Objection (4) to AW-155-17-PL – Build house in front garden of Brus Lodge, 28 Kingsway – 12-7-2017

OBJECTION (4) TO AW/155/17/PL - Build Detached House in front garden of Brus Lodge, 28 Kingsway, within the Craigweil House Conservation Area and the Craigweil House Area of Special Character.

ARBORICULTURAL REVIEW OF PLANNING APPLICATION AW/155/17/PL

Figure No. 01 – Tree Protection Measures (SH 02)

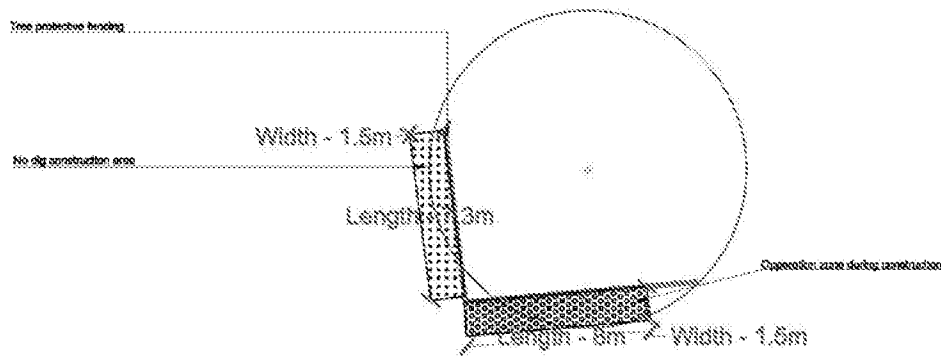
- I believe they have stated in error that the Bay Laurel will be retained whereas in fact the tree they show on all their plans is the Pittosporum in SH02 not the Bay which is outside the development site.

- 5.7 At 2.3 – *‘The bay is due to be retained and renovated, all basal growth is to be removed and the tree crown lifted to 1.50 metres height from the ground ...’*

- I believe they mean the Pittosporum and not the Bay.
 - As these works are not directly required to facilitate the development works and the site is within a Conservation Area I do not think they can legally do any works without first having submitted a Section 210 - 6 week notification of intent.

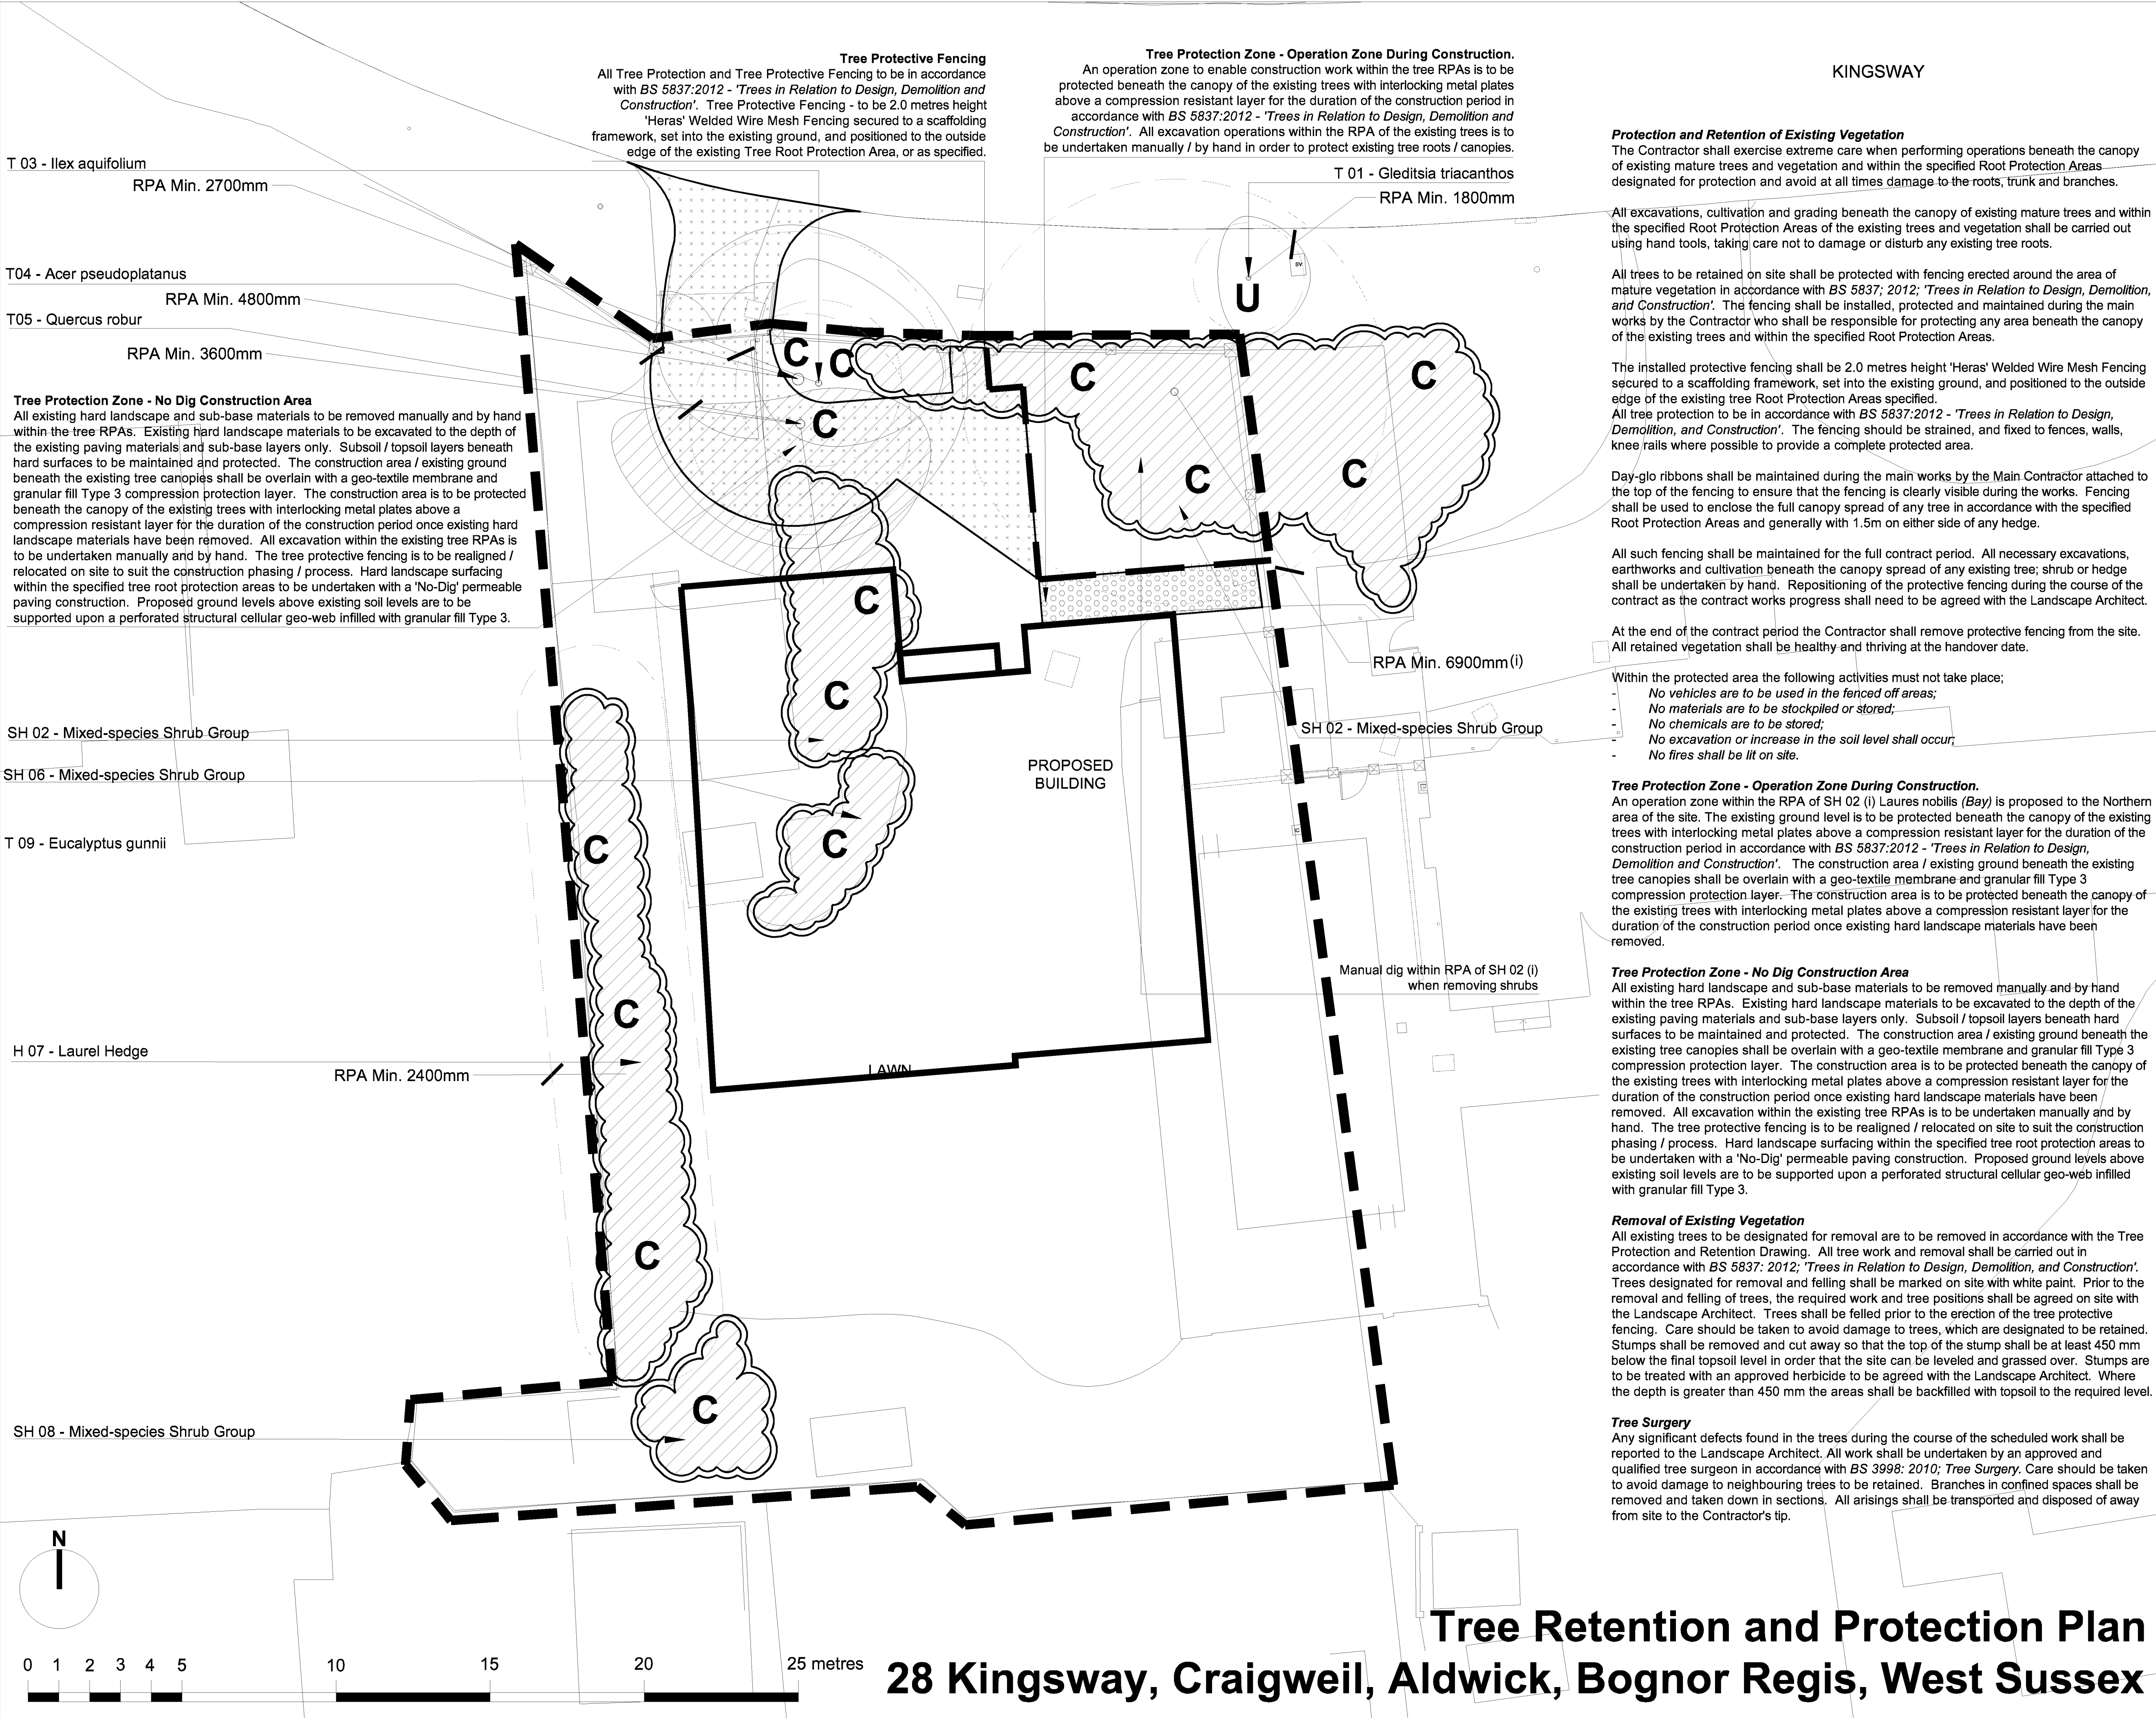
- There are two very significant Bay trees to the right hand side of the existing concrete access drive – neither are mentioned or even plotted on this plan. There appears to be scope to retain both trees.
- There is reference in the annotations on the plan to the Bay tree – surely they mean the Pittosporum?

- No Tree Protective Fencing is shown around the TPO'd Norway Maple and Holly.
- No protective fencing is shown outside to encompass the grass verge all of which is within the RPA's of the Pittosporum and Maple.
